Recommendation Report

Application No. BE/104/11

Proposed Detached Garage on Land Adjacent to 37 The Croft (BE/104/11)

Proposed New Detached Single Garage
at
Land Adjacent to 37 The Croft, Bognor Regis
for
Mr R Lailey
Drawing PG03 July 2011 Scale 1:100
Proposed Plan, Roof Plan and Elevations

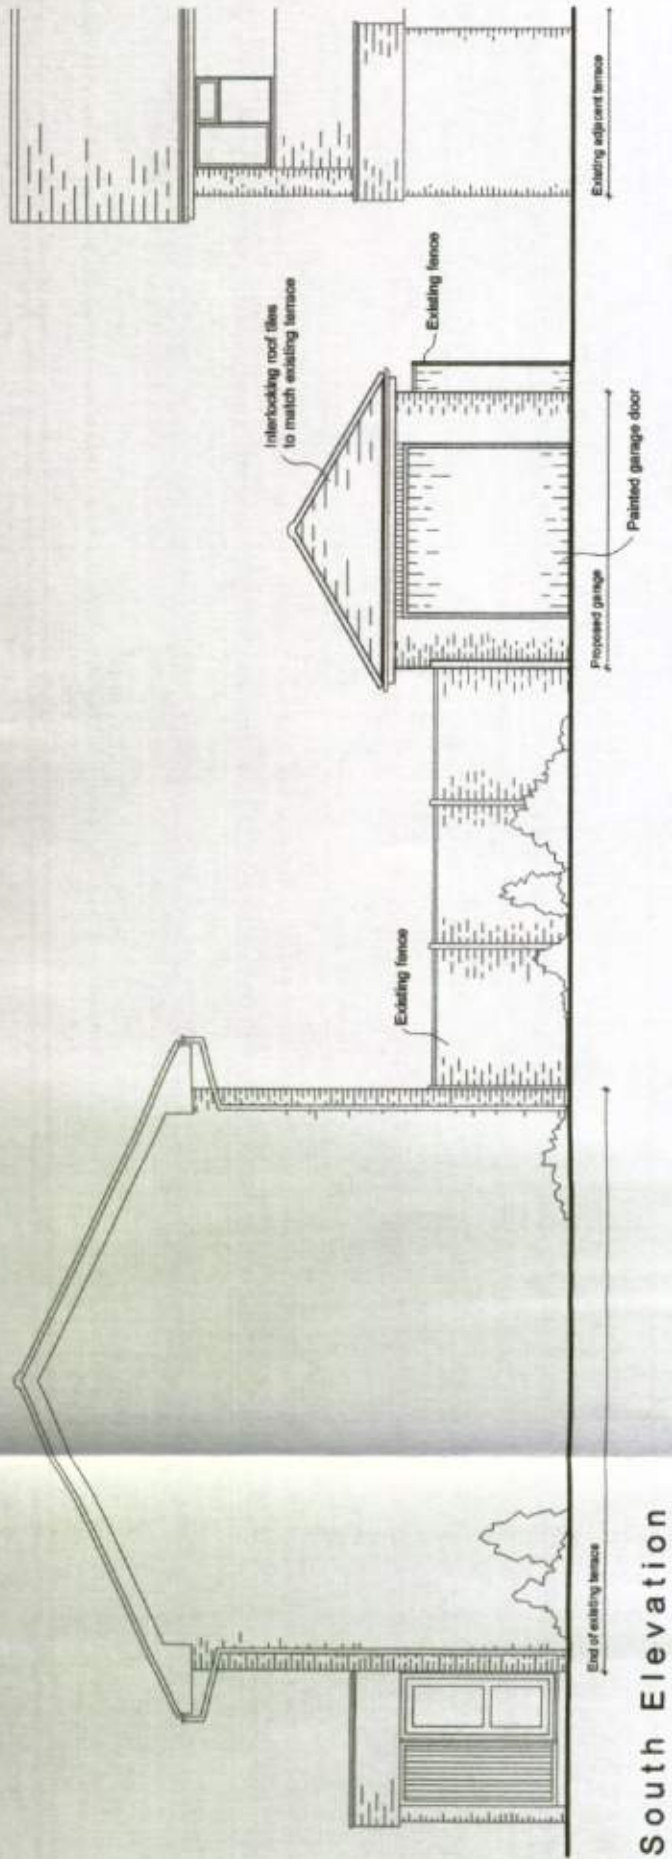
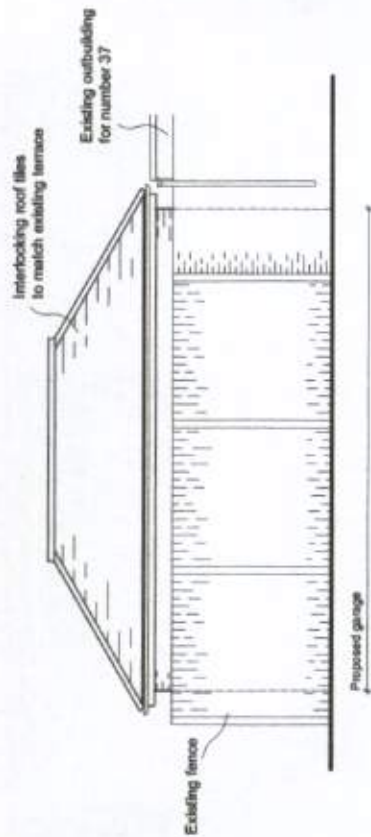
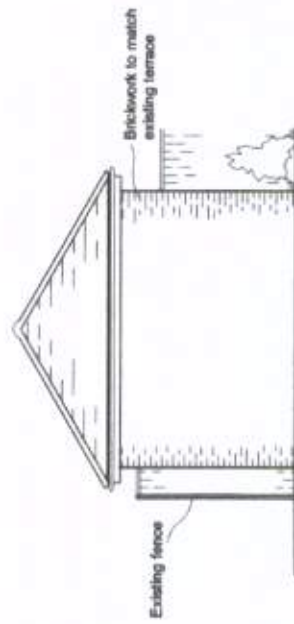
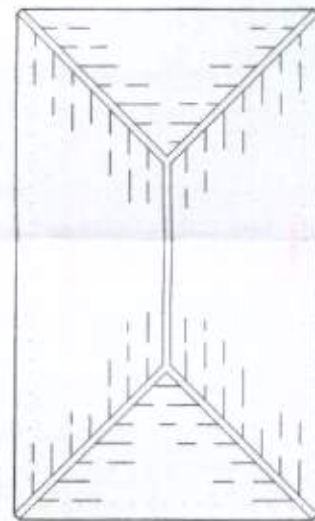
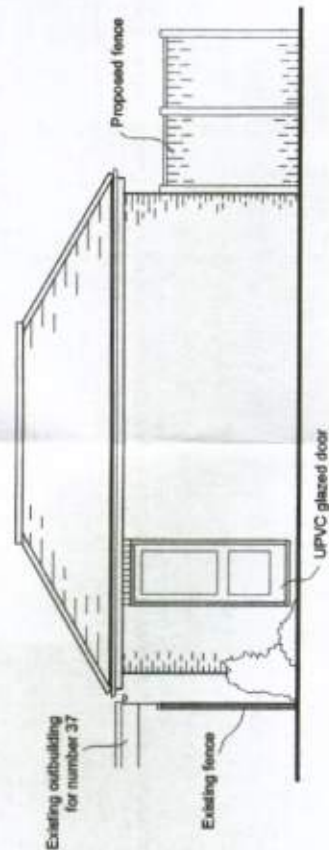
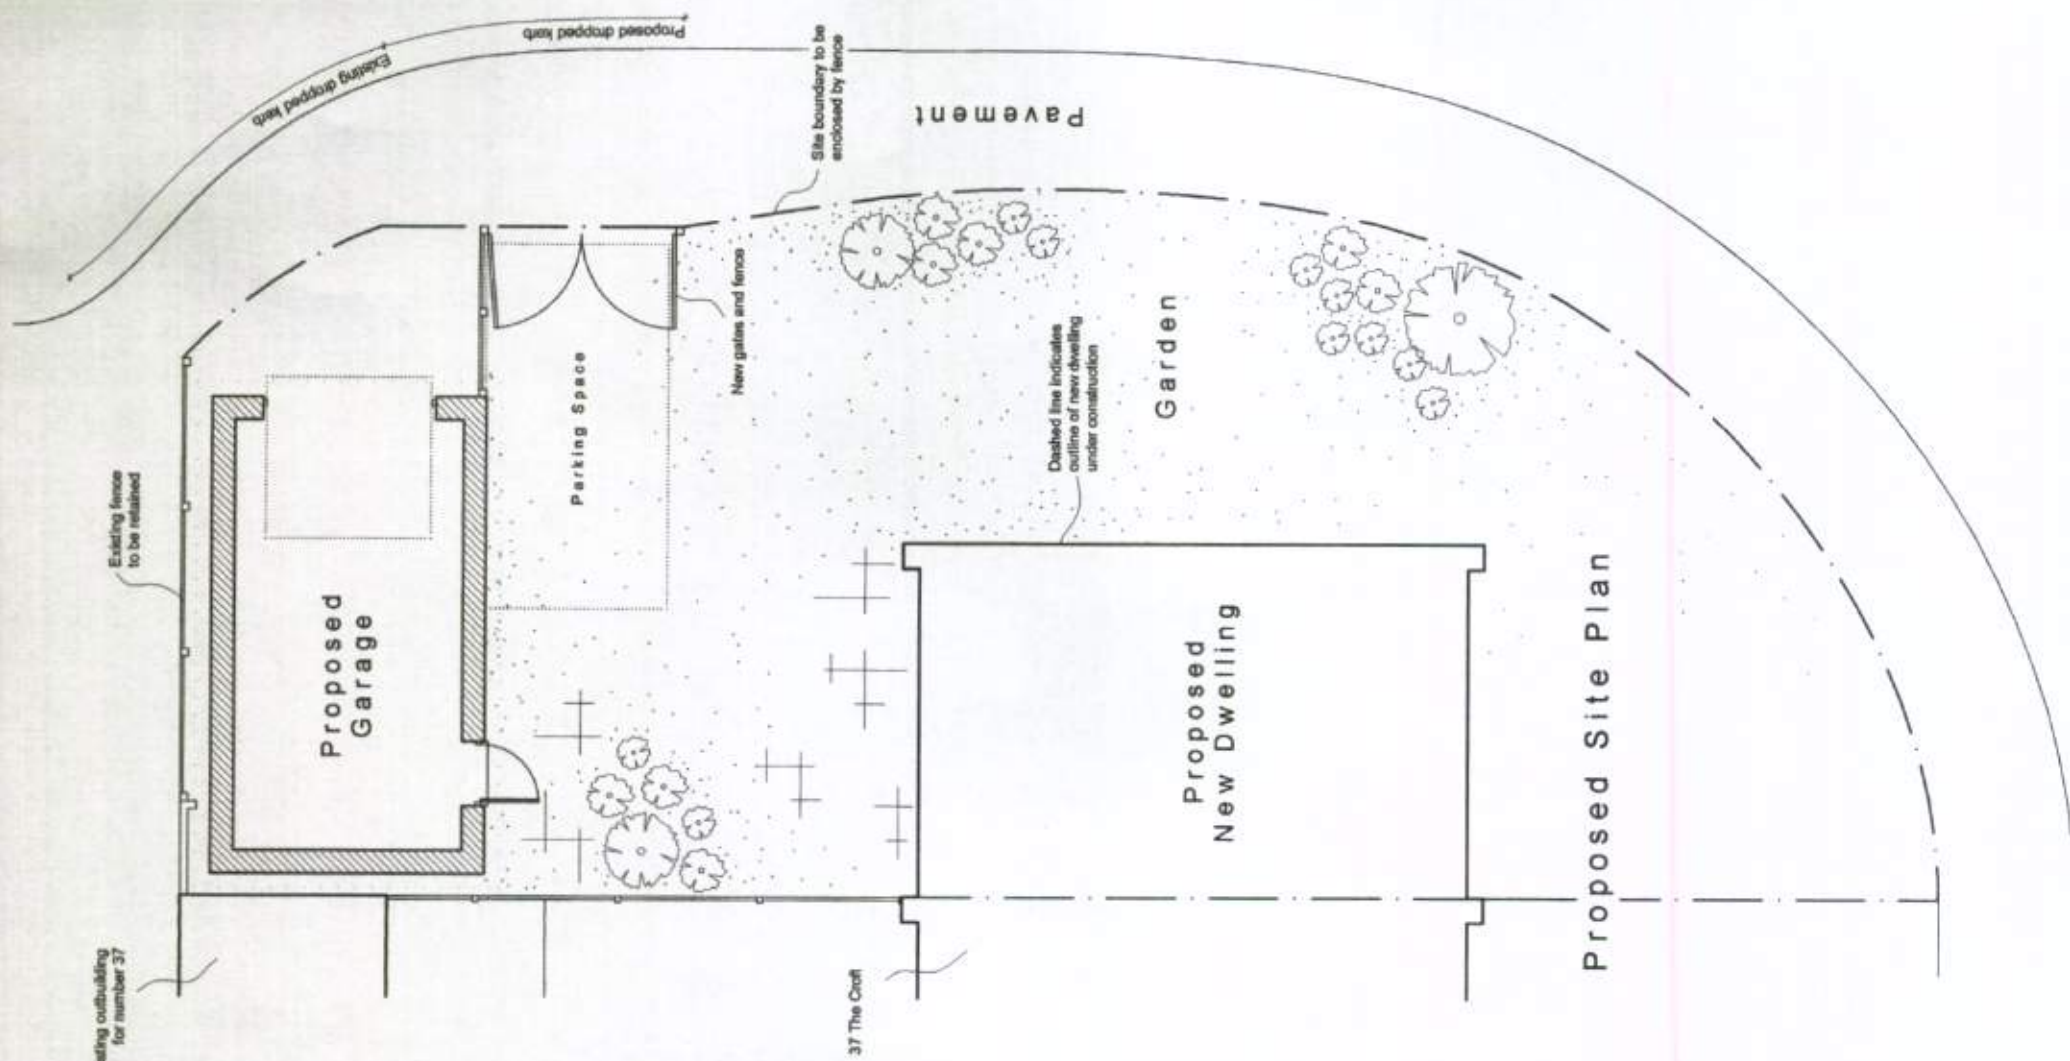
I have discussed the application with my Team Leader and substitute plans may be submitted to amend the design to a flat roof garage.

Given the comments in your report regarding the roof, would it be possible to change the design to a flat roof before the application goes to committee? Obviously my Client is keen to have the best possible chance of getting a consent, and as the roof was regarded as "out of keeping" by some of the objectors to the scheme, he wondered whether it would be wise to change the design.

The proposed garage has been revised from a tiled hipped roof to a flat roof, in light of some of the comments and objections to the scheme. In addition, the front porch has been shown on the plans, and the area designated as private amenity space for the dwelling indicated.

Proposed New Detached Single Garage
at Land Adjacent to 37 The Croft, Bognor Regis
for Mr R Lailey
Drawing PG04a July 2011 Scale 1:500 / 1:1250
Block Plan and Location Plan

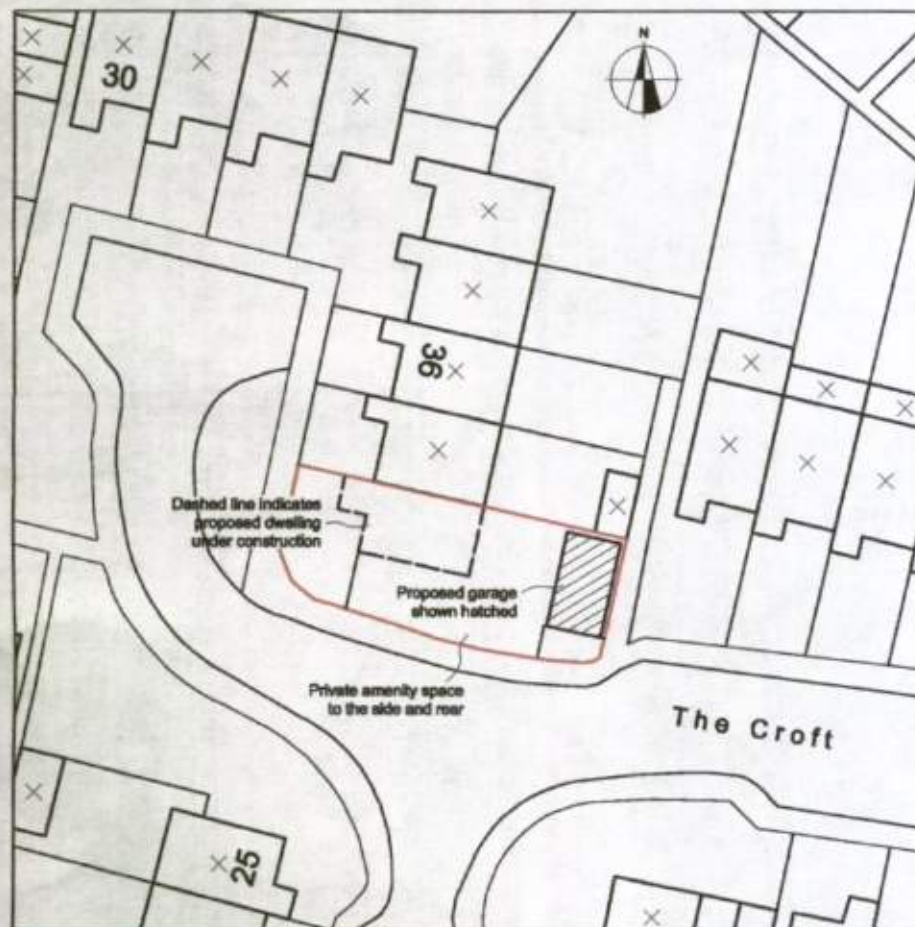
- The front porch - this does not appear to be shown on the submitted site plan PG03;
- Private amenity space to the rear and side, and ideally the amount of private amenity space available for occupiers. This was a particular issue for Members at the previous Planning Committee and will therefore need to be addressed as part of the committee report.

Proposed New Detached Single Garage
at Land Adjacent to 37 The Croft, Bognor Regis
for Mr R Lailey
Drawing PG03b July 2011 Scale 1:100
Proposed Plan, Roof Plan and Elevations

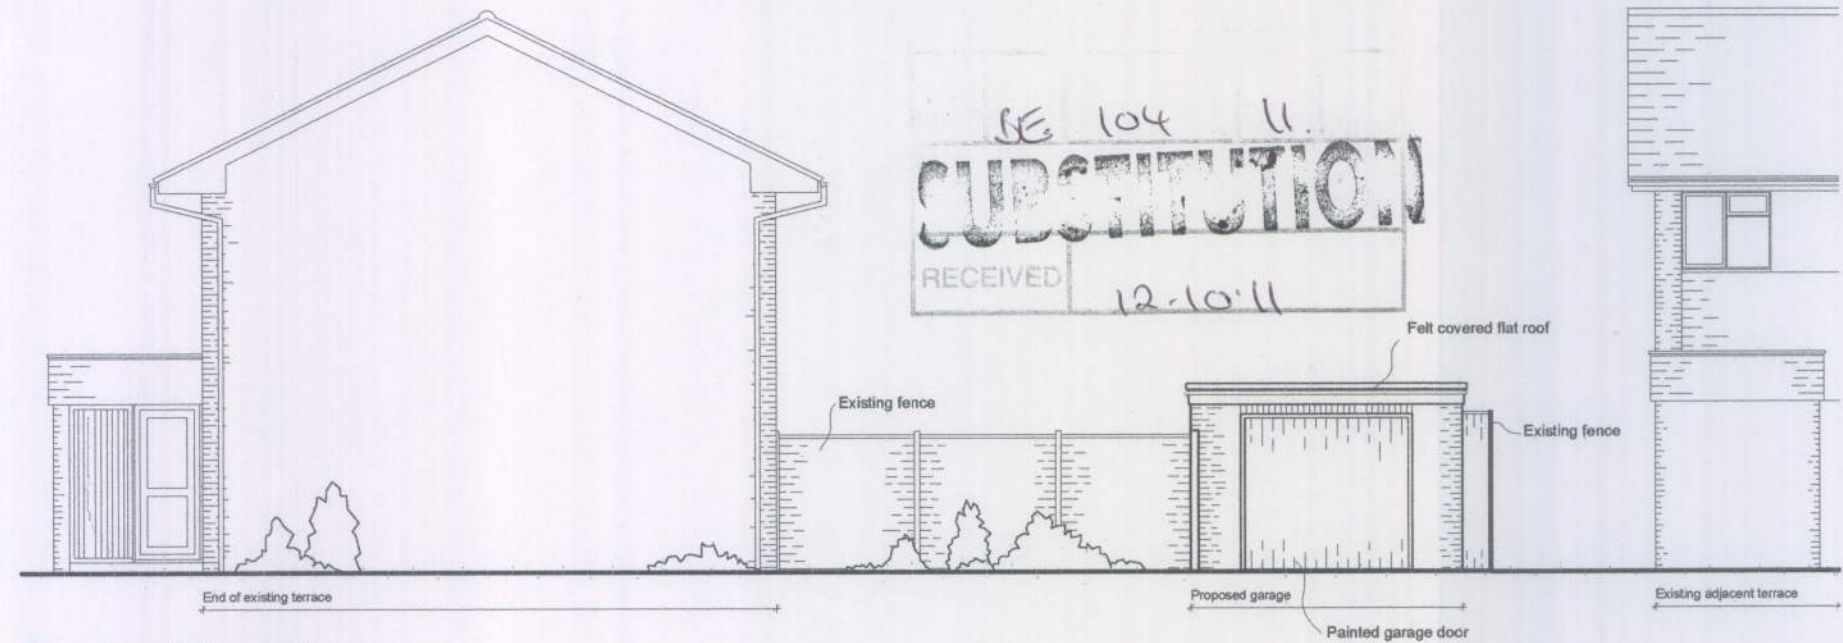
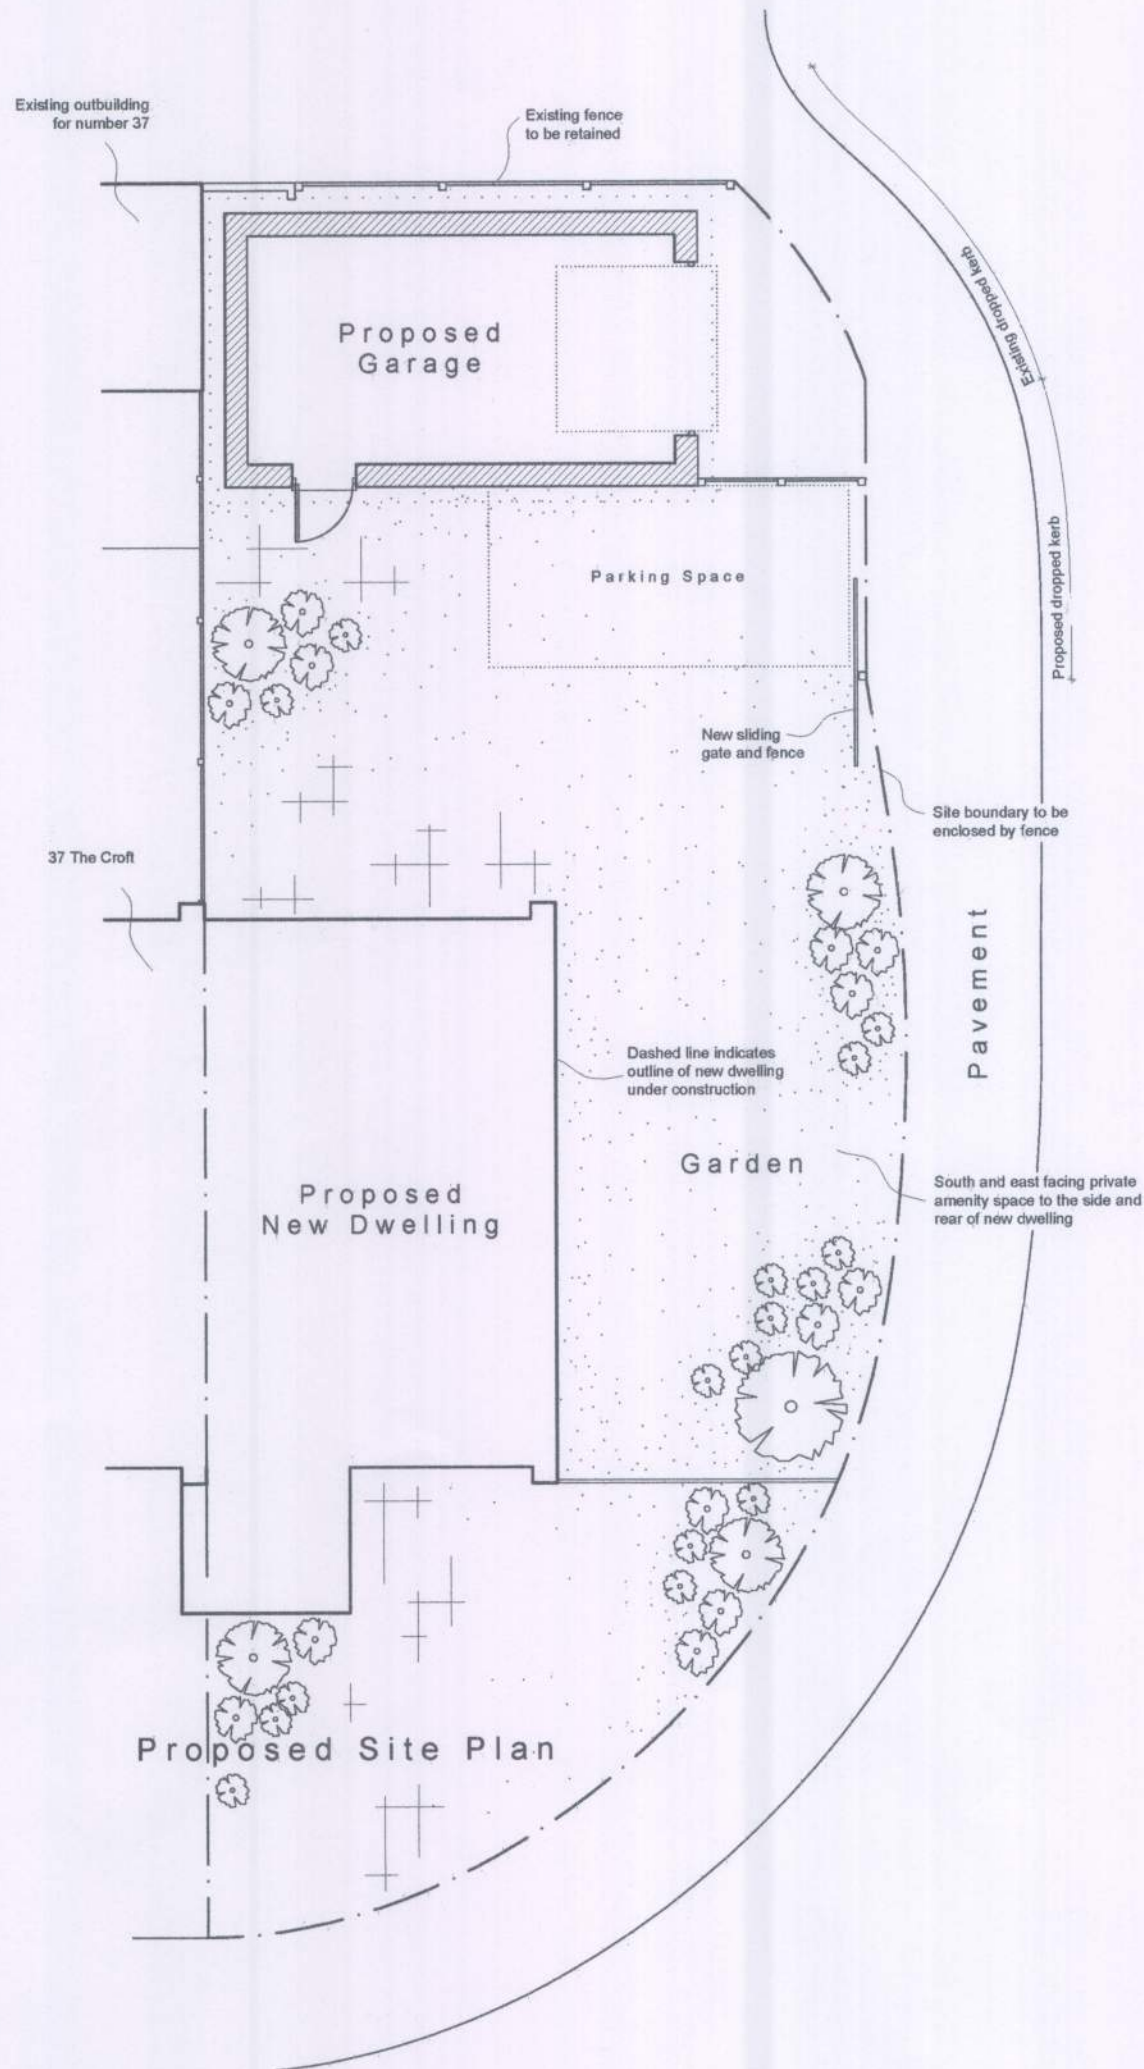
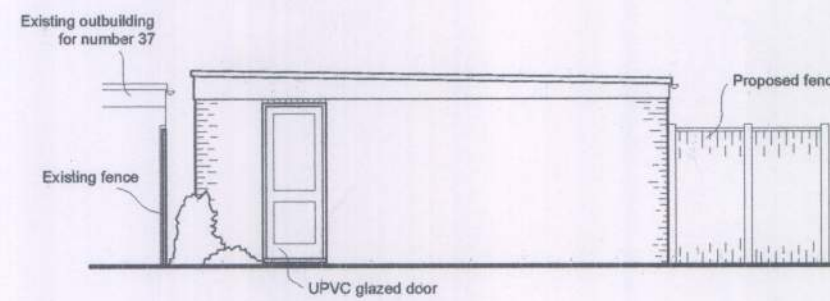
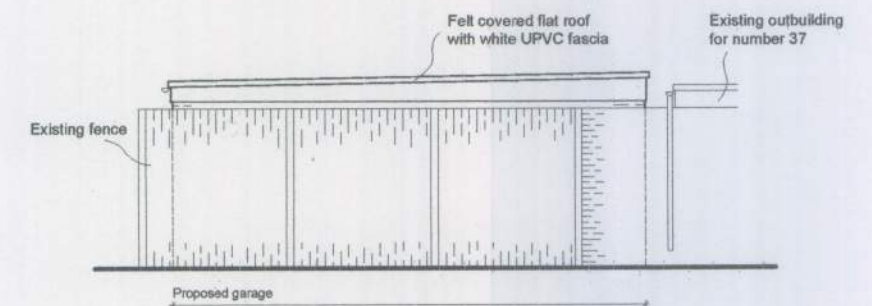
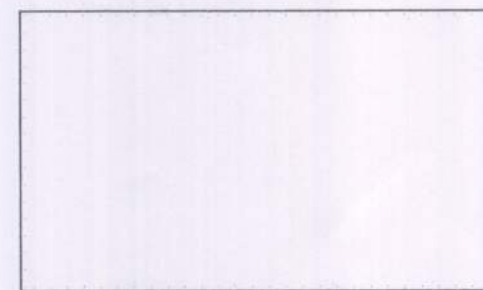
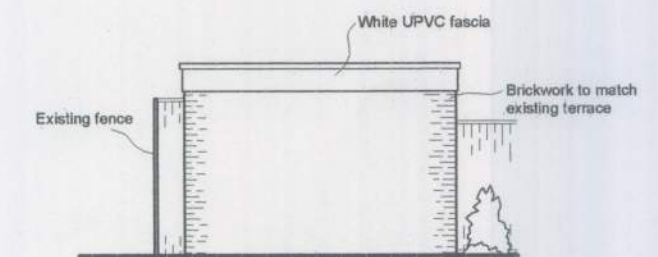
Having discussed the revised scheme with my Team Leader, please can the proposed gates to the hardstanding be amended to sliding gates, as there would appear to be insufficient room to open/close the gates with a car parked on the hardstanding.

As requested, the double gates to access the parking space have been replaced with a single sliding gate.
